DECISION DELEGATED TO HEAD OF PLANNING

Application No: H16-0250-25 **Applicant:** Mr S Brown
Proposal: Conversion of loft to habitable space, internal alterations, addition of dormer window to west elevation, re-roof & reinstatement of historic windows
Location: Monks House Bourne Road Spalding
Terminal Date: 26th May 2025

CASE OFFICER ASSESSMENT

PROJECT TITLE:	MONK'S HOUSE, BOURNE RD, SPALDING		
DRAWING TITLE:	GROUND FLOOR PLANS		
DRAWING NO.:	2548-PP01	REVISION:	-
PAGE SIZE:	A3	SCALE:	1:100

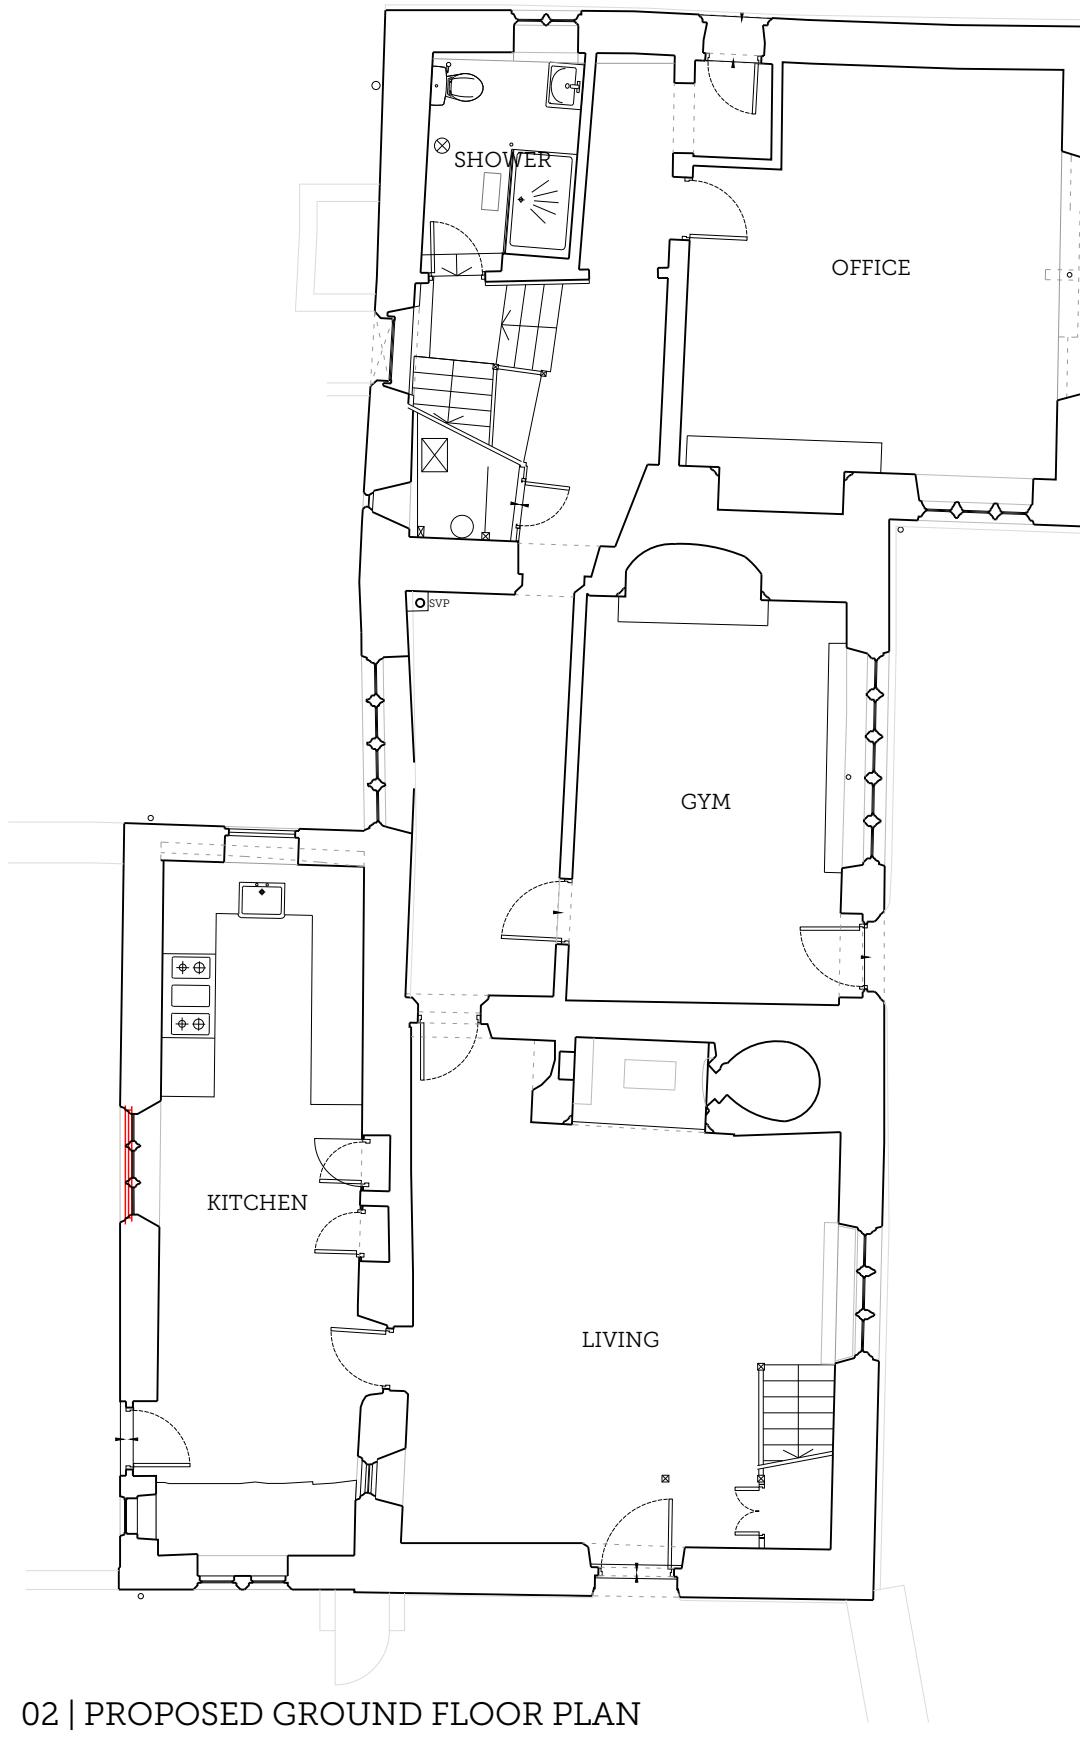
Windows: The HS describes the opening up of windows at attic level. While we do not object to this in principle, further detailed information is required to show the design and specification of the proposed window to assess the impact on the surrounding historic fabric. The drawings also show that the ground floor kitchen window will be replaced. However, the age of the existing window is unknown, and the proposed new window is not described.

Further information is required to understand the proposal and assess the impact of the window replacement.

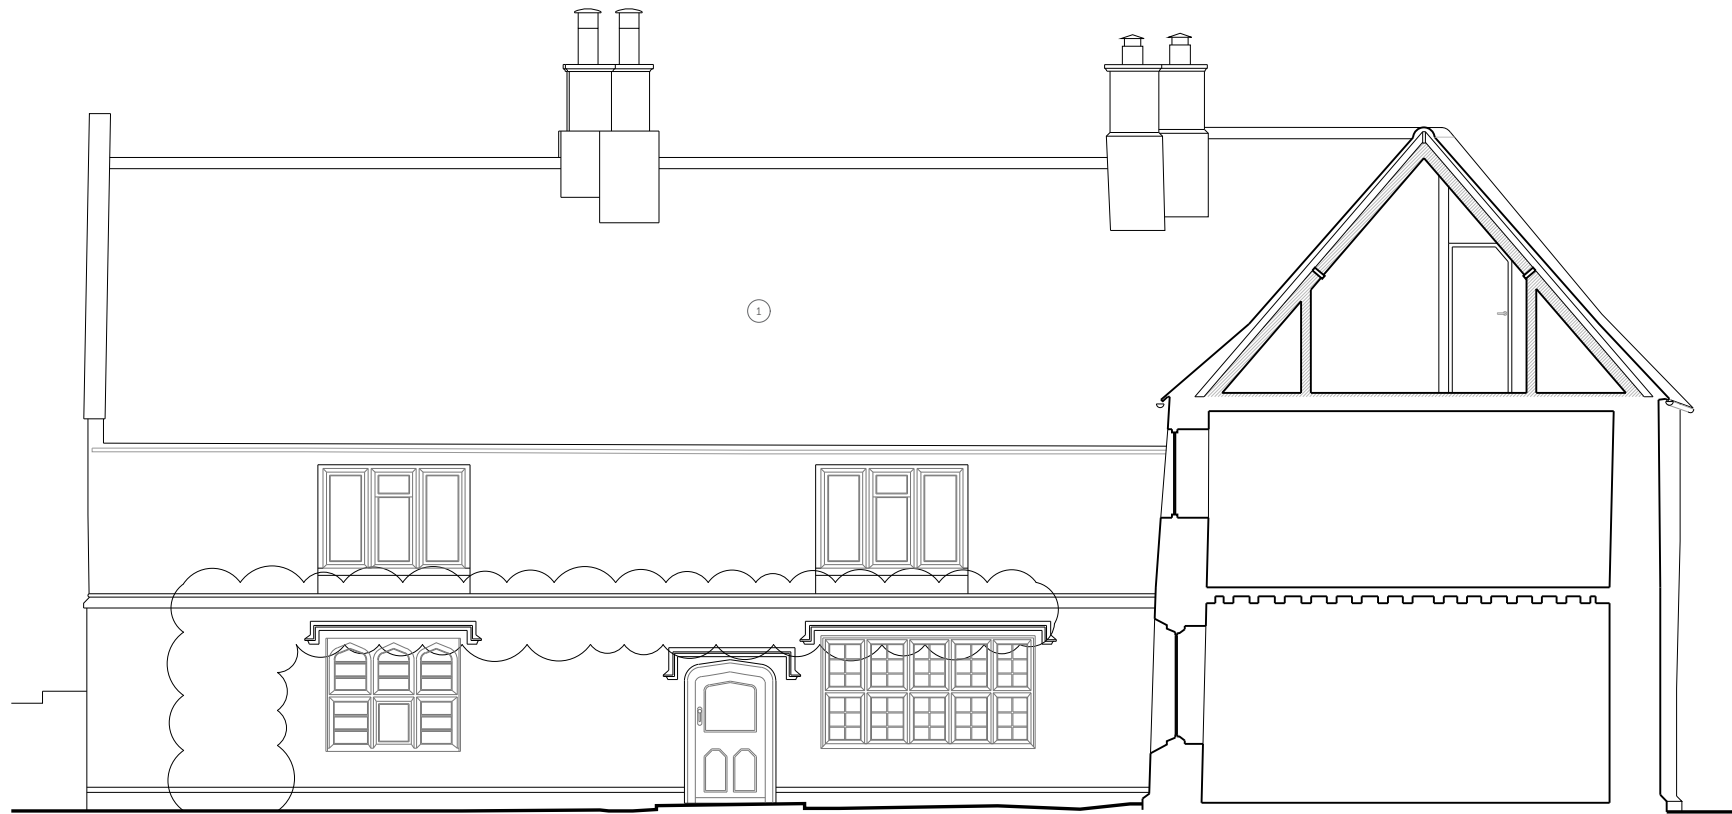
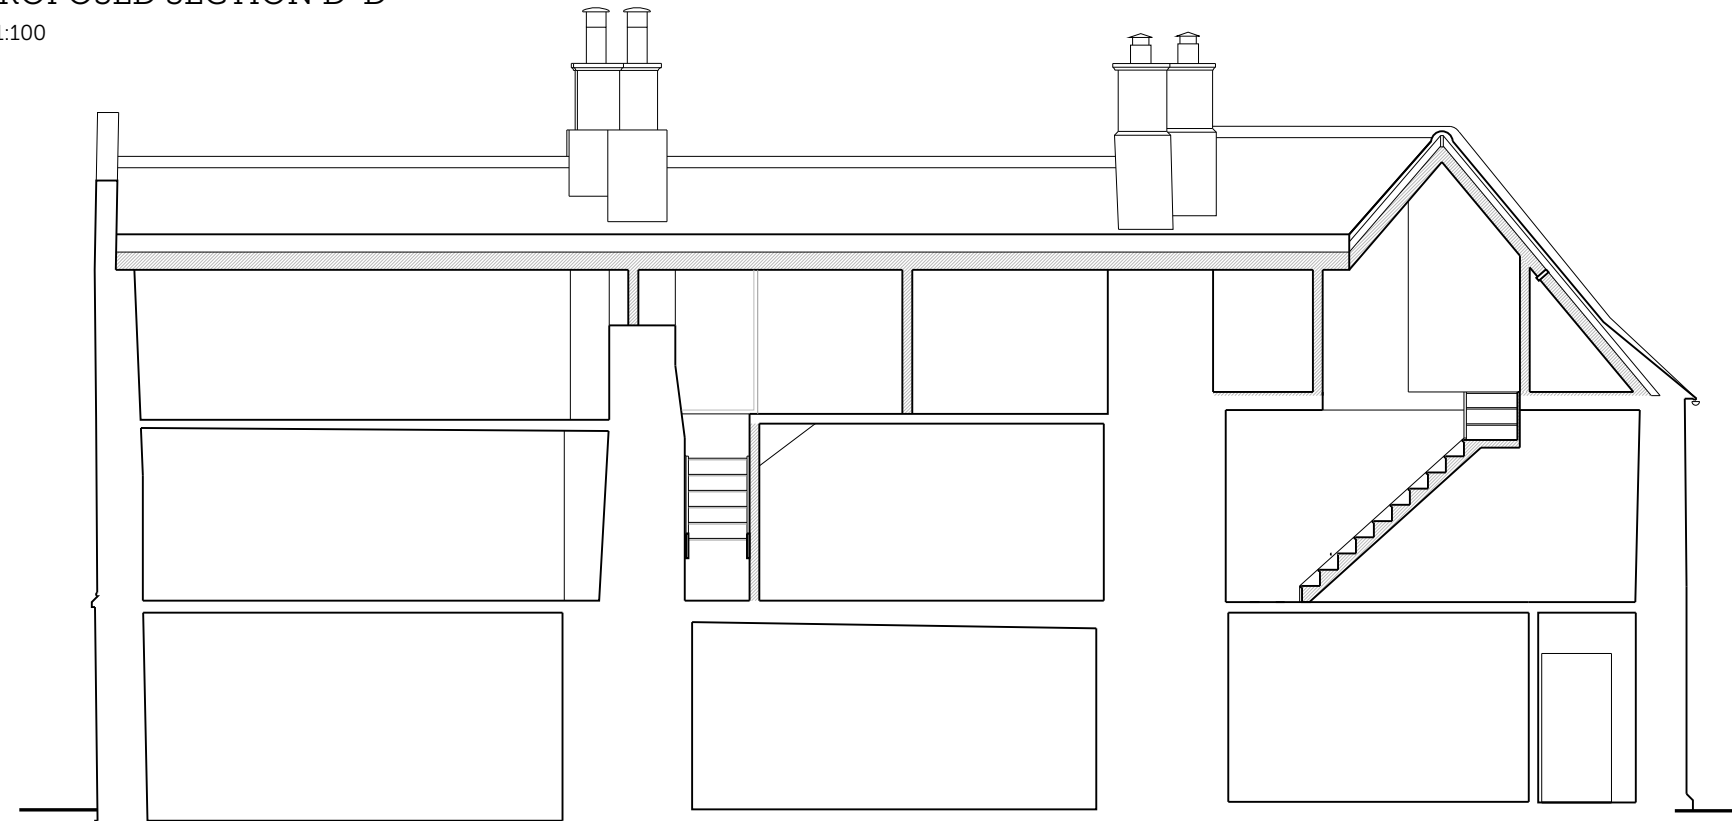
That being said, it is considered that the proposed dormer window significantly conflicts with the character of the building itself. The dormer window is a clearly modern feature, which juxtaposes the historic fabric of the building and fails to respect the existing character of the site. As a result, the proposal is not integrated into the overall design of the existing dwelling. The proposal therefore conflicts with Paragraph 3.3.3 of the SELLP, in that the extension is not integrated into the original building.

As a dormer window, it would be readily visible when the building is viewed from multiple directions, further exacerbating its impact. This projection would also fail to respect the existing character of the dwelling, which has historically been characterised by this sloping roof.

It is considered that the proposed dormer window would introduce a highly incongruous element, which completely juxtaposes with the historic nature of the building, thereby harming the significance of the heritage asset. In this instance, less than substantial harm has been identified.
